CITY OF ALBUQUERQUE

April 7, 2016

**Re: Hillside Auto Sales, LLC
134 Tennessee St. NE
Request Permanent C.O. - Accepted
Engineer's Stamp dated: 10-21-14 (K19D148)
Certification dated: 4-4-16**

TRAFFIC CIRCULATION LAYOUT

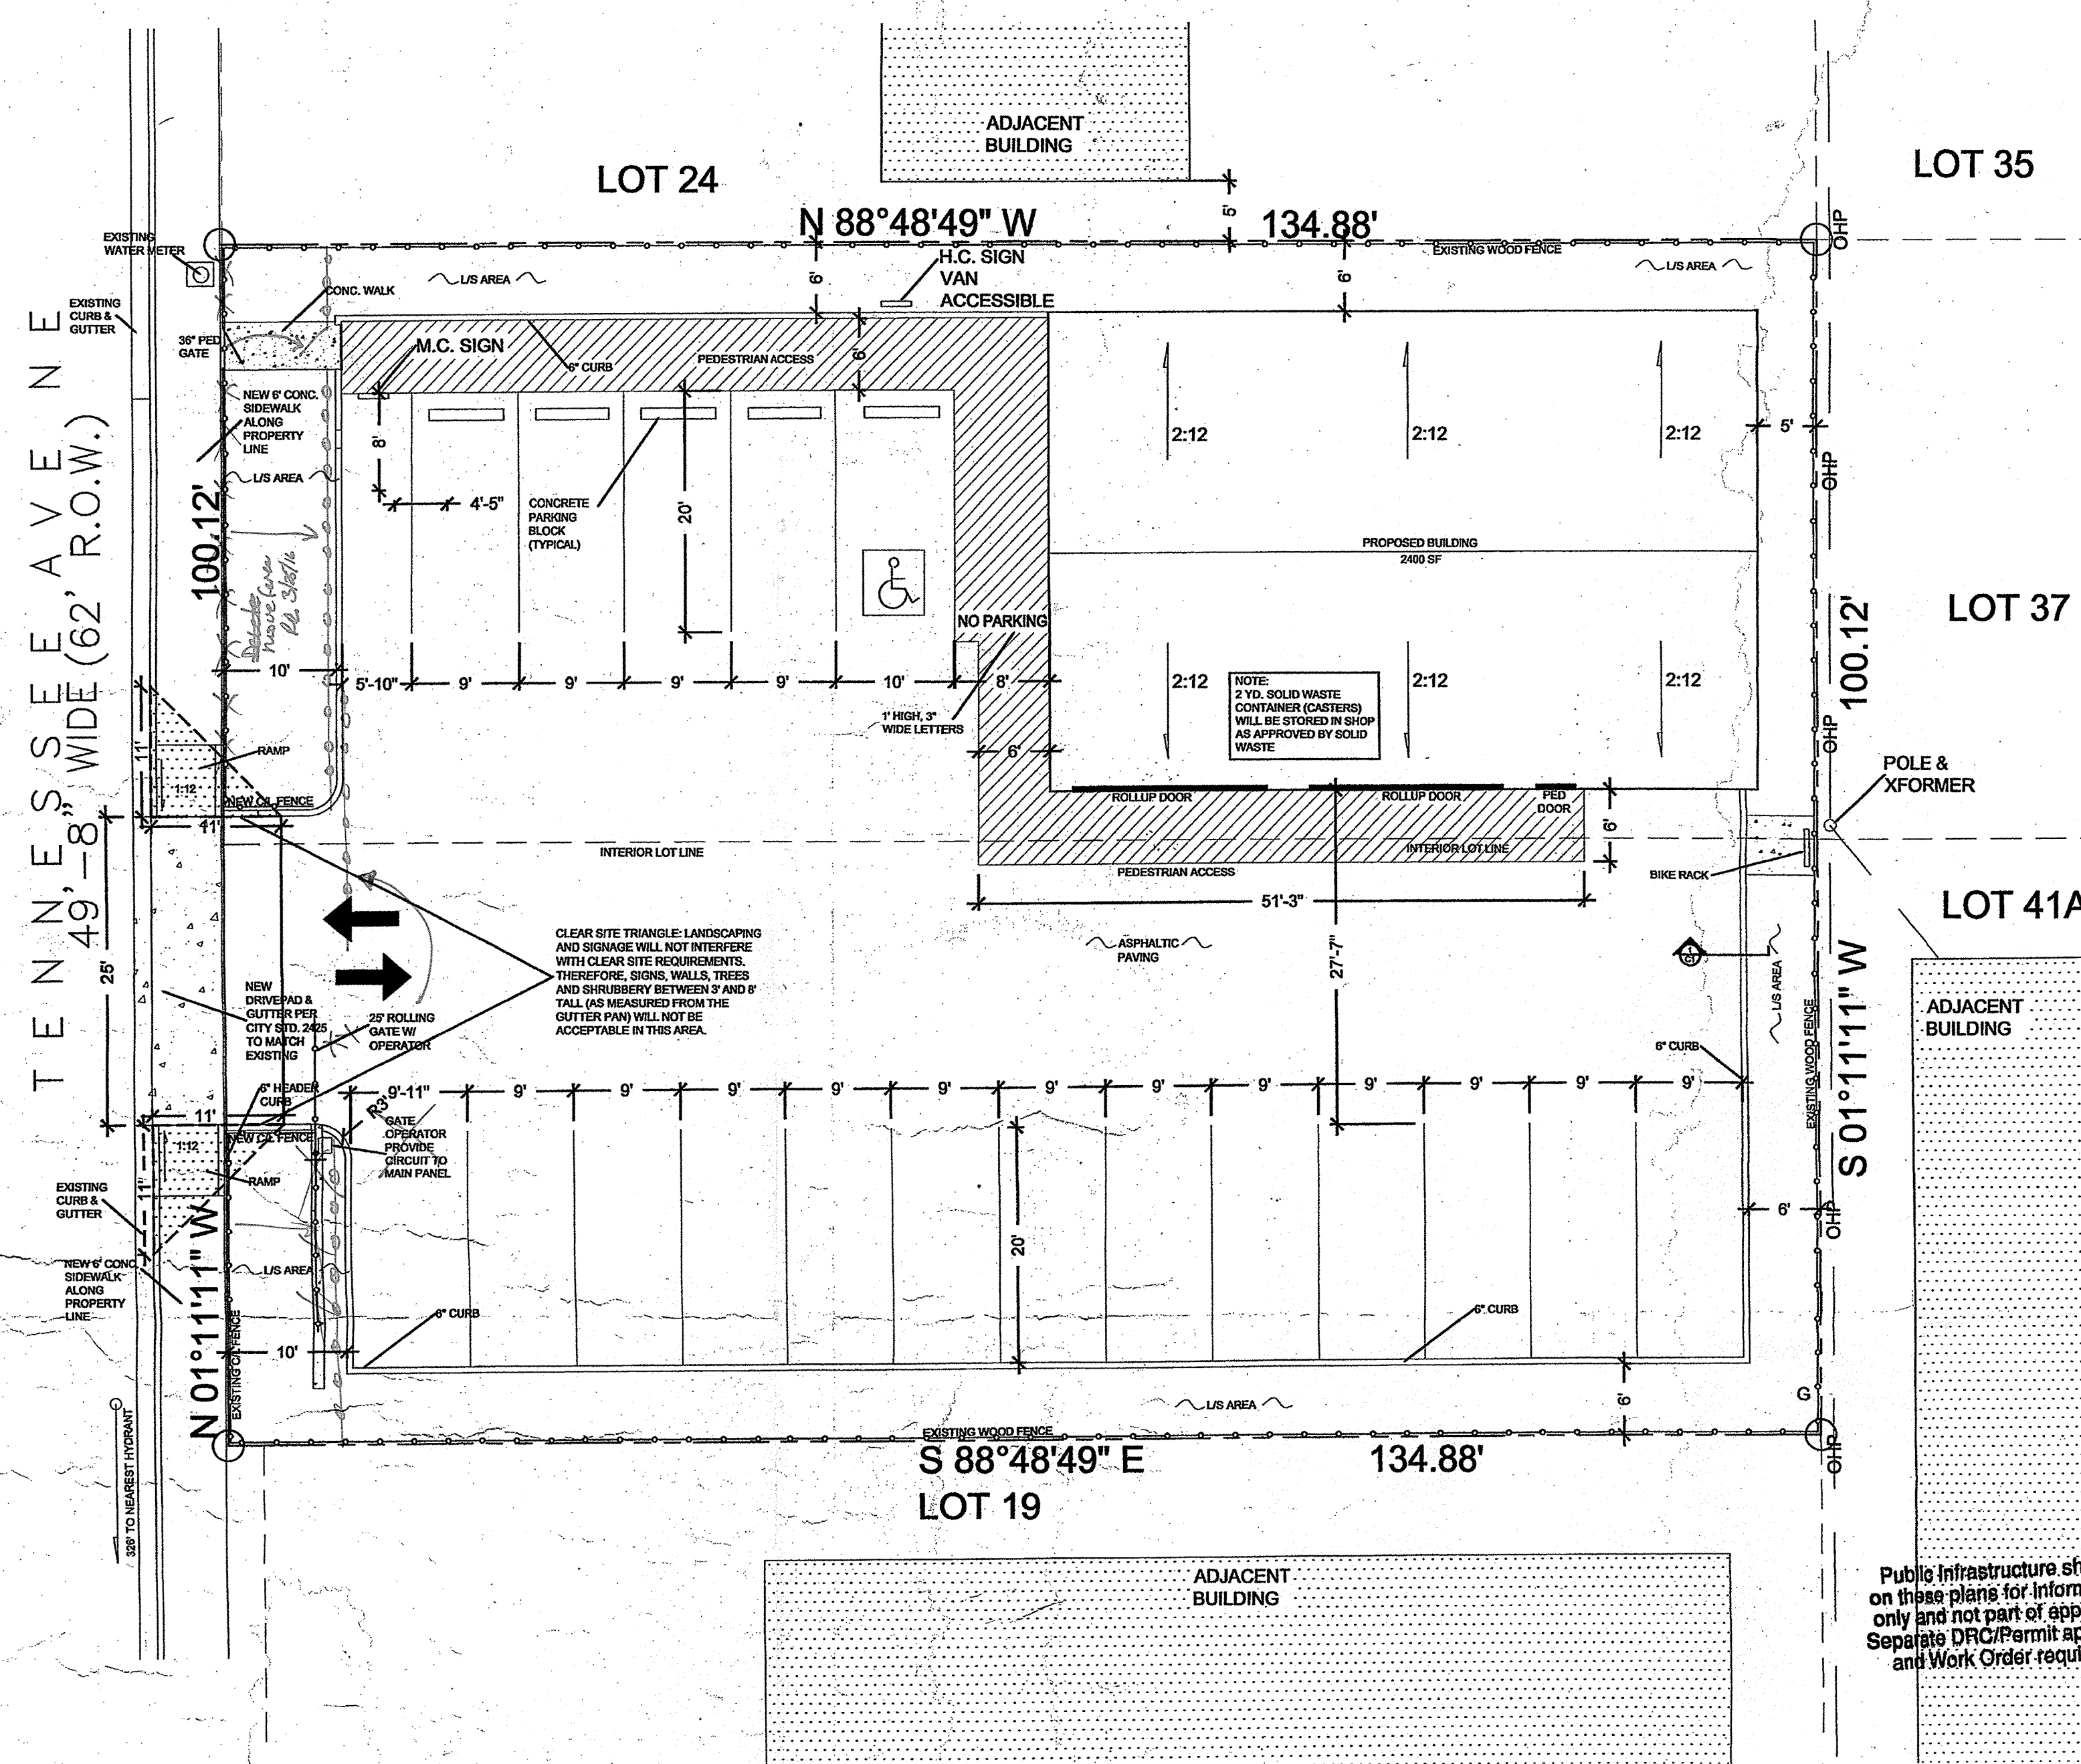
1. Is the pedestrian 6-foot pathway asphalt? If so, label it as asphalt, and somehow indicate that it shall have a 2% maximum cross-slope. Also, provide striping delineating the walkway from the driving area south of the building.
2. You still have the words "Pedestrian Access" shown where the original 6-foot pathway was shown. Go ahead and delete this.

- PO Box 1293
- Albuquerque
- New Mexico 87103
- www.cabq.gov
1. NMBC Table 1106.1 requires 1 ADA accessible parking space which also needs to be Van accessible. (The handicapped space is required to be a minimum of 8.5 feet in width, and the handicapped van accessible aisle is required to be 8.0 feet in width.)

2. Please identify all existing or proposed doors and sidewalks that influence the parking and circulation on-site.
 3. Identify the existing street width for Tennessee Street.

4. The ADA accessible parking sign must have the required language per 66-7-352.4C NMSA 1978 **"Violators Are Subject to a Fine and/or Towing."** Also, include the "Van Accessible" language per ANSI 502.7.

5. The ADA access aisle shall have the words **"NO PARKING"** in capital letters, each of which shall be at least one foot high and at least two inches wide, placed at the rear of the parking space so as to be close to where an adjacent vehicle's rear tire would be placed. (66-1-4.1.B NMSA 1978)

6. Label the light, dashed line that runs through the middle of the site plan.
 7. A 6-foot-wide ADA accessible pedestrian pathway is required from the existing 6-foot public sidewalk to the building entrances. Please clearly show this pathway and provide details. This pedestrian pathway cannot be within the driving area. Also, a 6 ft. wide ADA accessible pedestrian pathway is required from the HC parking stall access aisles to the building entrances.

8. Design delivery vehicle route needs to be shown.
 9. Service vehicle and/or refuse vehicle maneuvering must be contained on-site.

10. It is not apparent what type of pavement or pavement thickness is being proposed on-site.
11. Please show clear site triangle per DPM Requirements, and add the following note to the clear sight triangle: "Landscaping and signage will not interfere with clear sight requirements. Therefore, signs, walls, trees, and shrubbery between 3 and 8 feet tall (as measured from the gutter pan) will not be acceptable in this area."
12. Tactile devices on either side of new drivepad are not required. They can be deleted.
13. Add a keyed note on the plan view to provide a new 6-foot wide concrete sidewalk along the full length of the property adjacent to Tennessee Street as you have indicated would be needed in Design Standard Note 7.
14. Please include two copies of the traffic circulation layout for the next submittal.
